Submission of a Non-Material Amendment to Planning Permission Ref: 20/P/01273 at 20 The Street, West Horsley, Leatherhead, KT24 6AX

We hereby submit a non-material amendment (S96a) to amend condition 1 of the approved development, under application ref: 20/P/01273.

Notes:

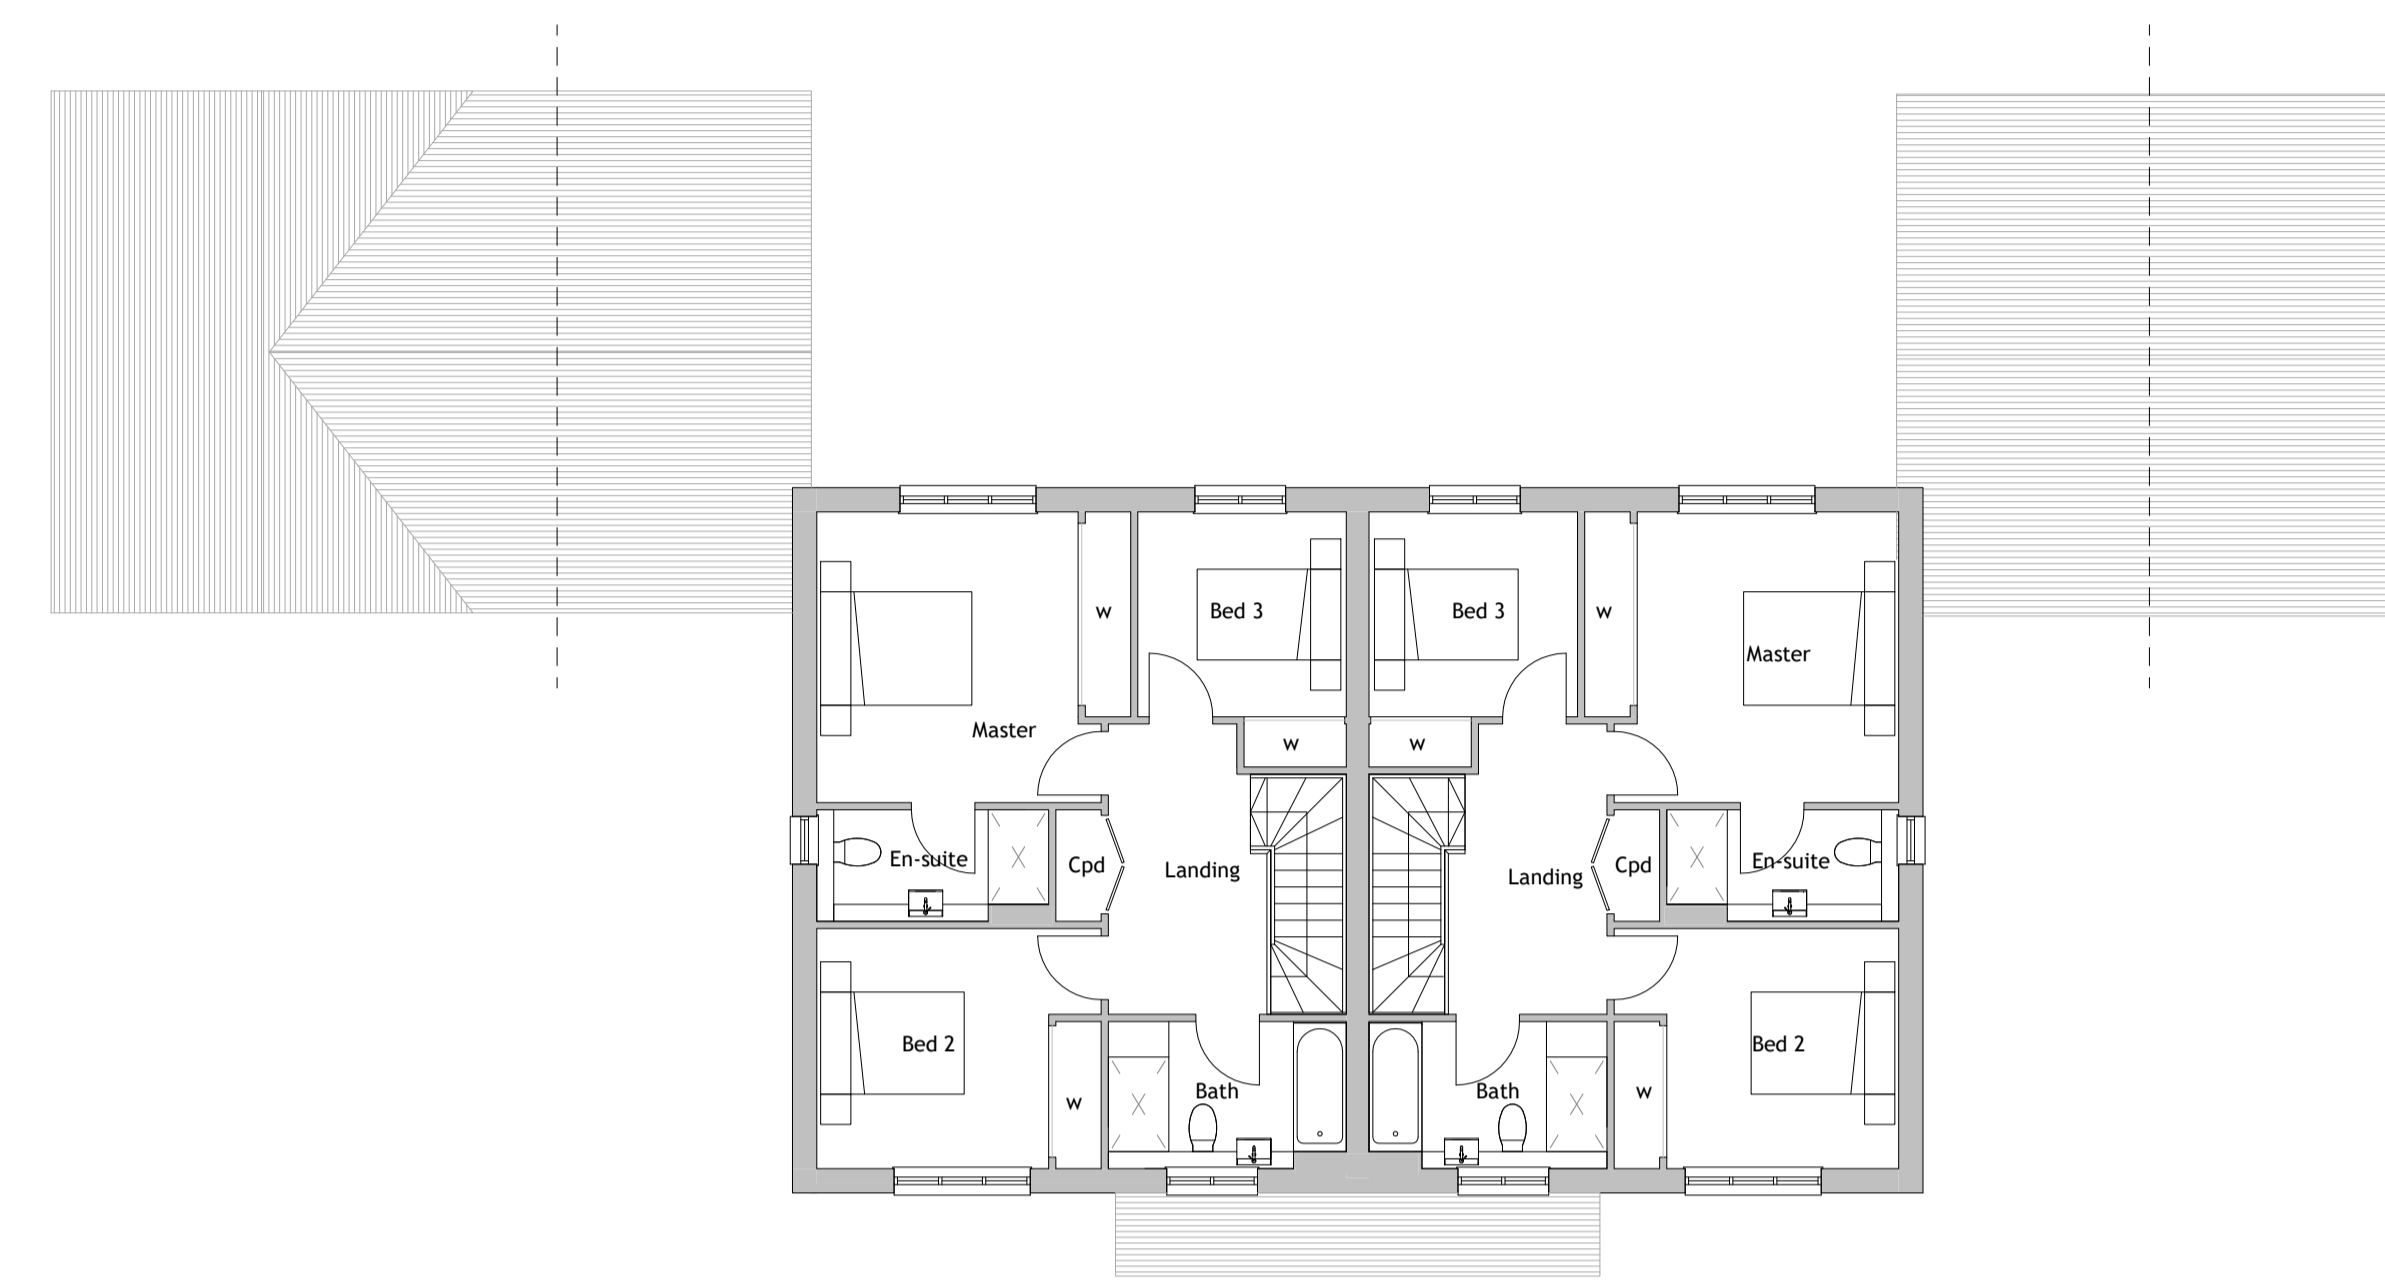
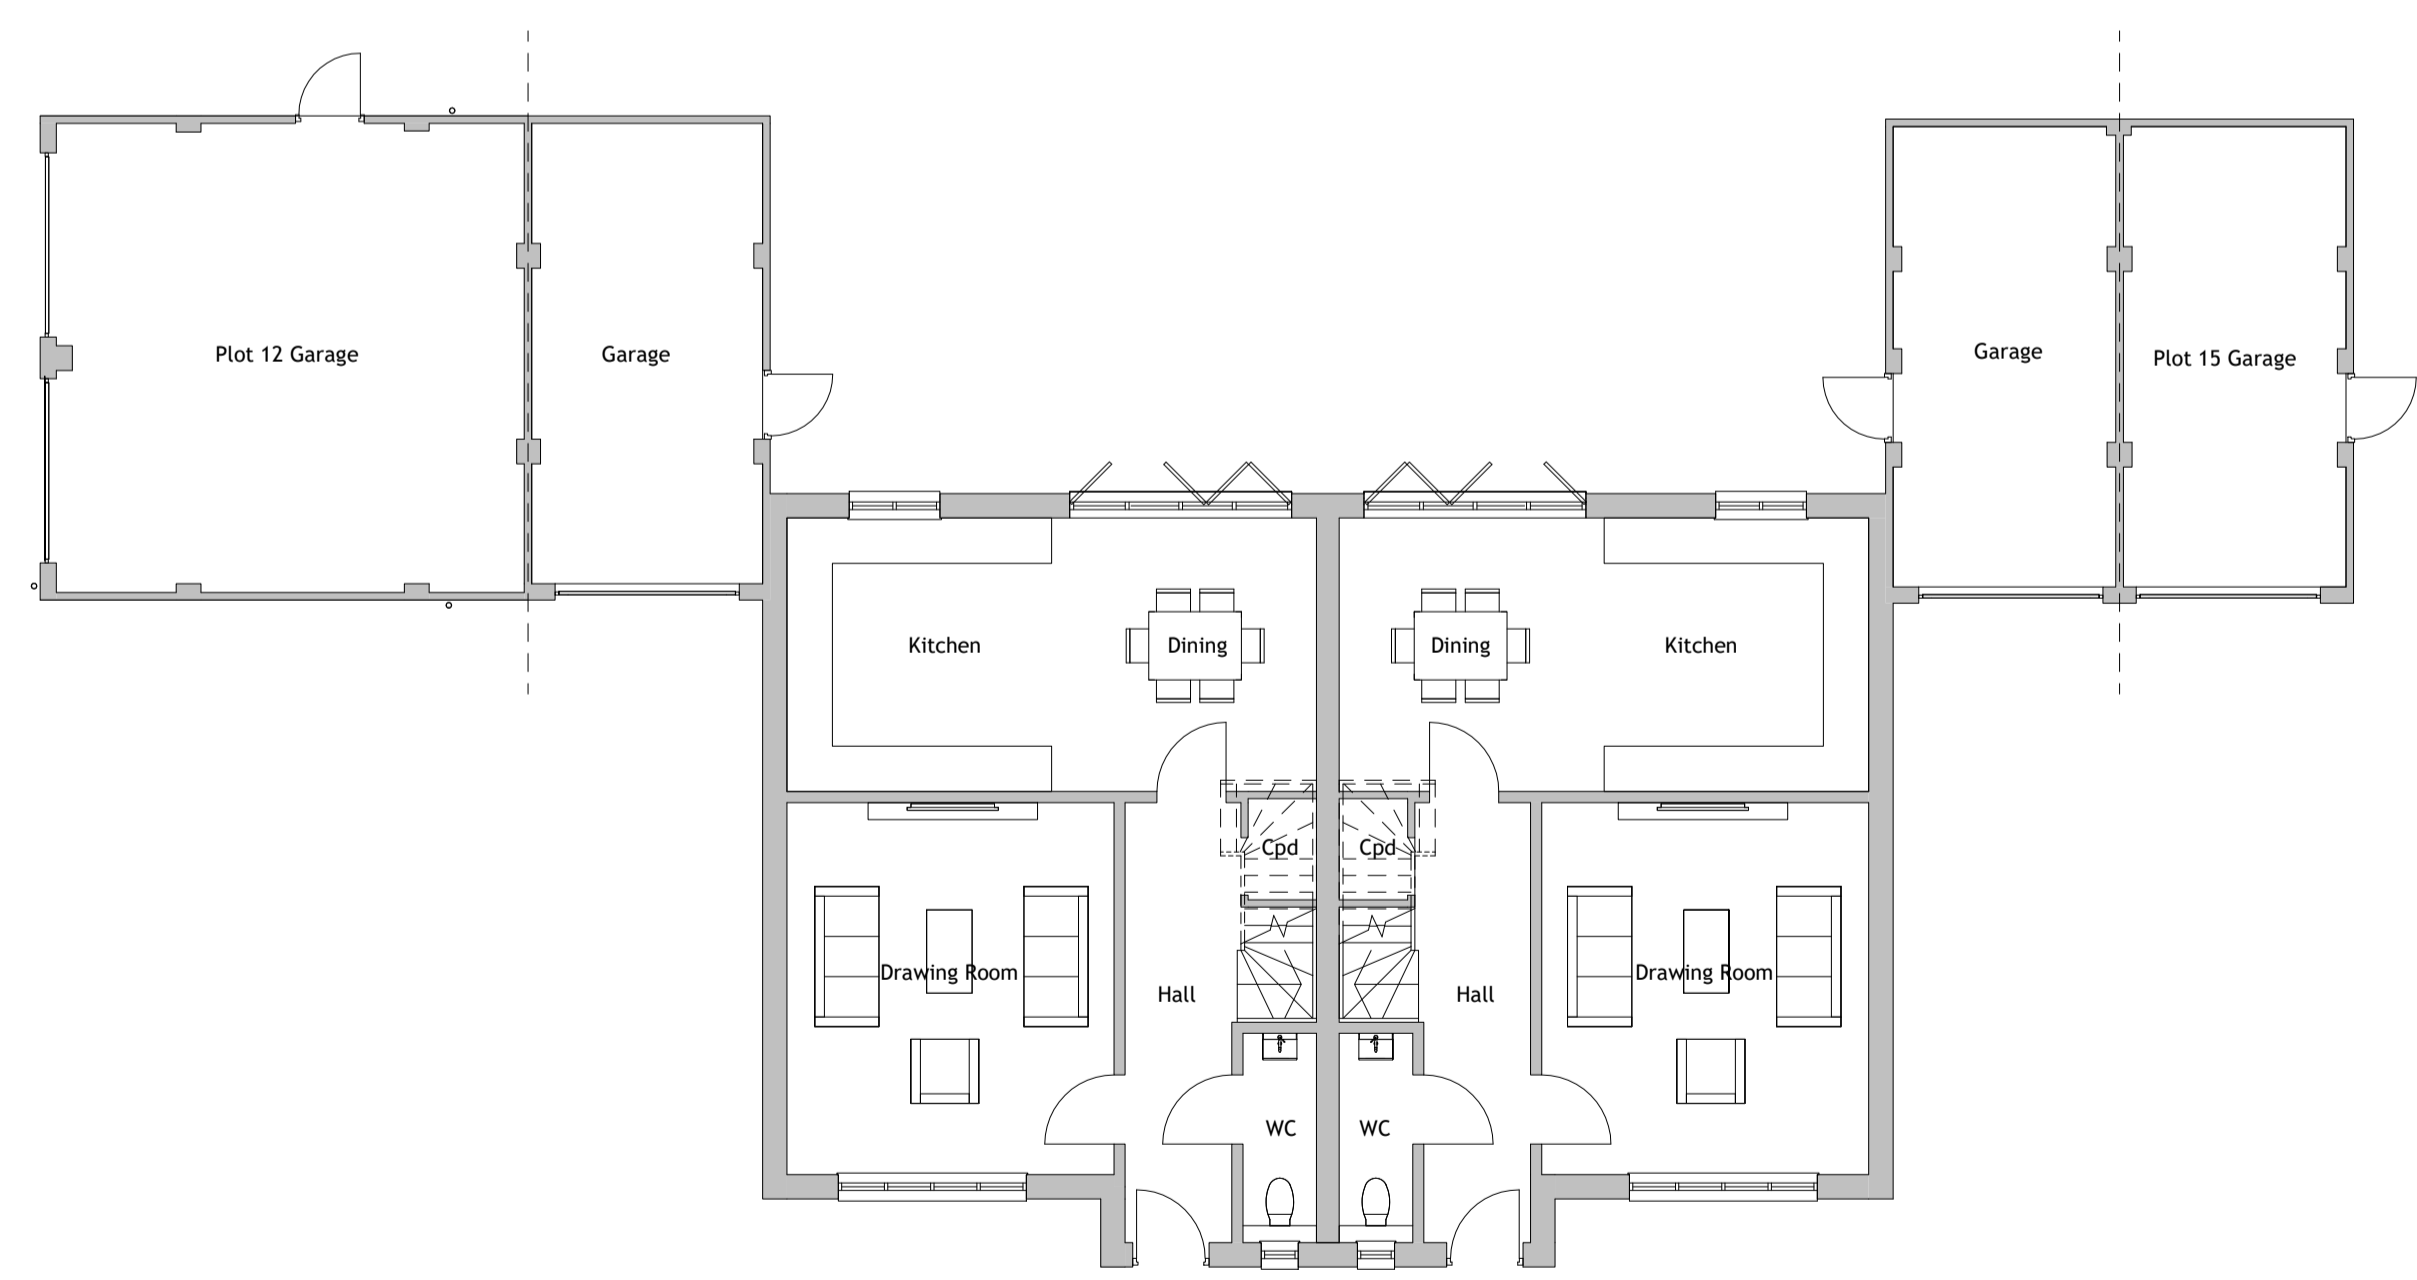
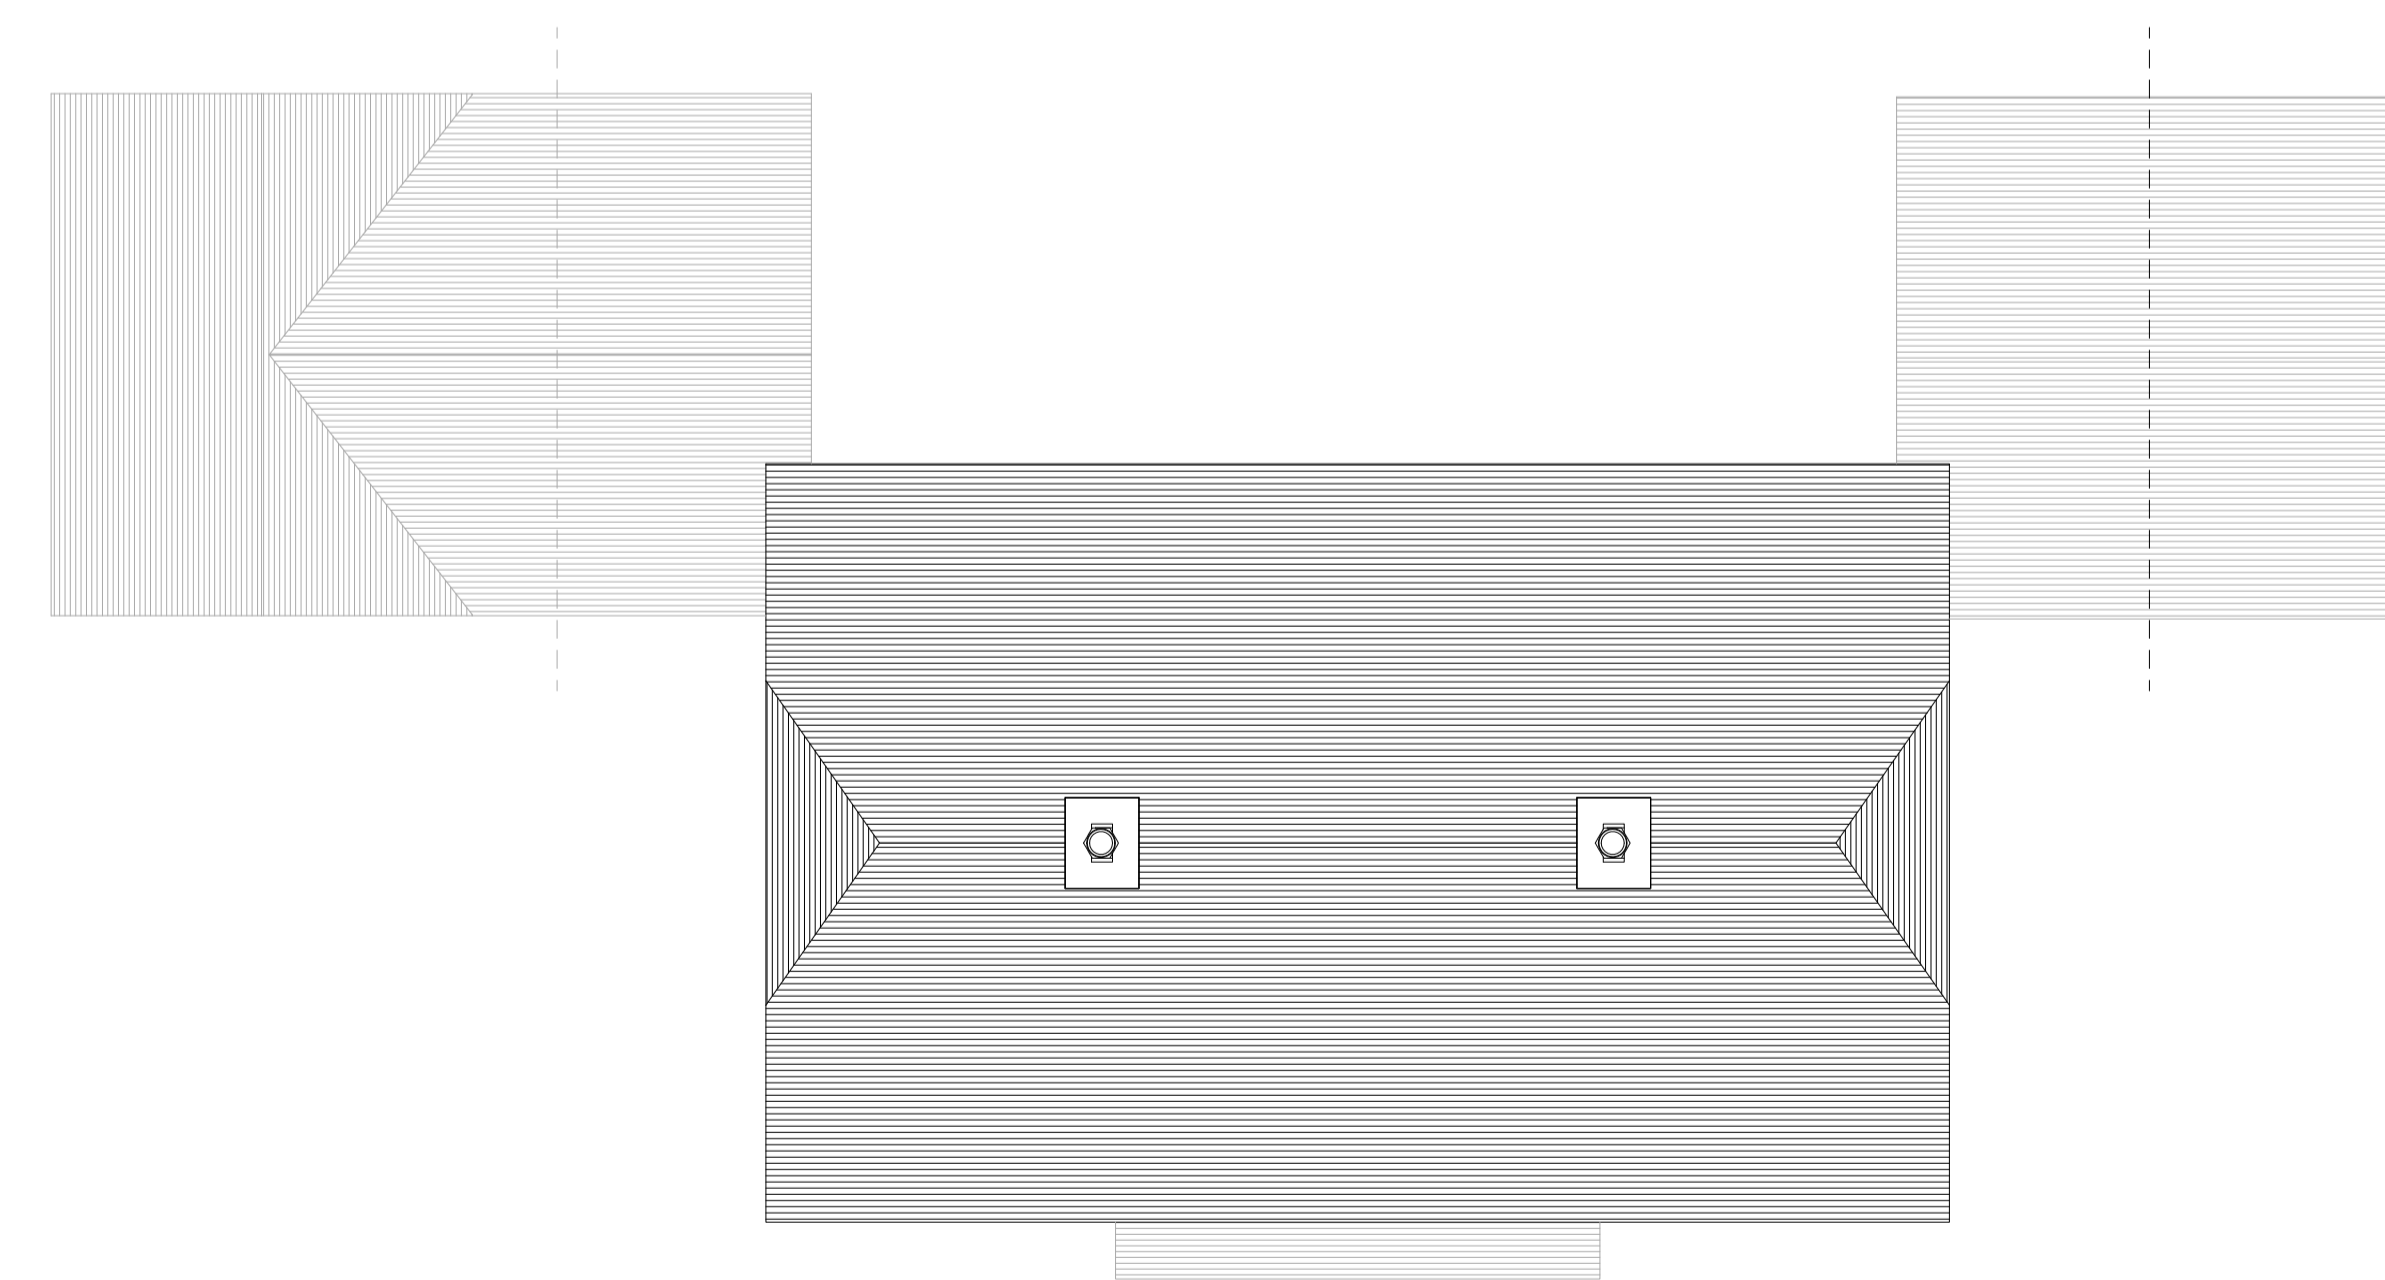
This amendment seeks only to relocate the double garage at plot 12, to adjoin the garage at plot 13. There is a legal covenant through the garden and driveway of plot 12 that restricts built structure in that area, therefore the location of the garage needs to be moved, so it falls outside this area.
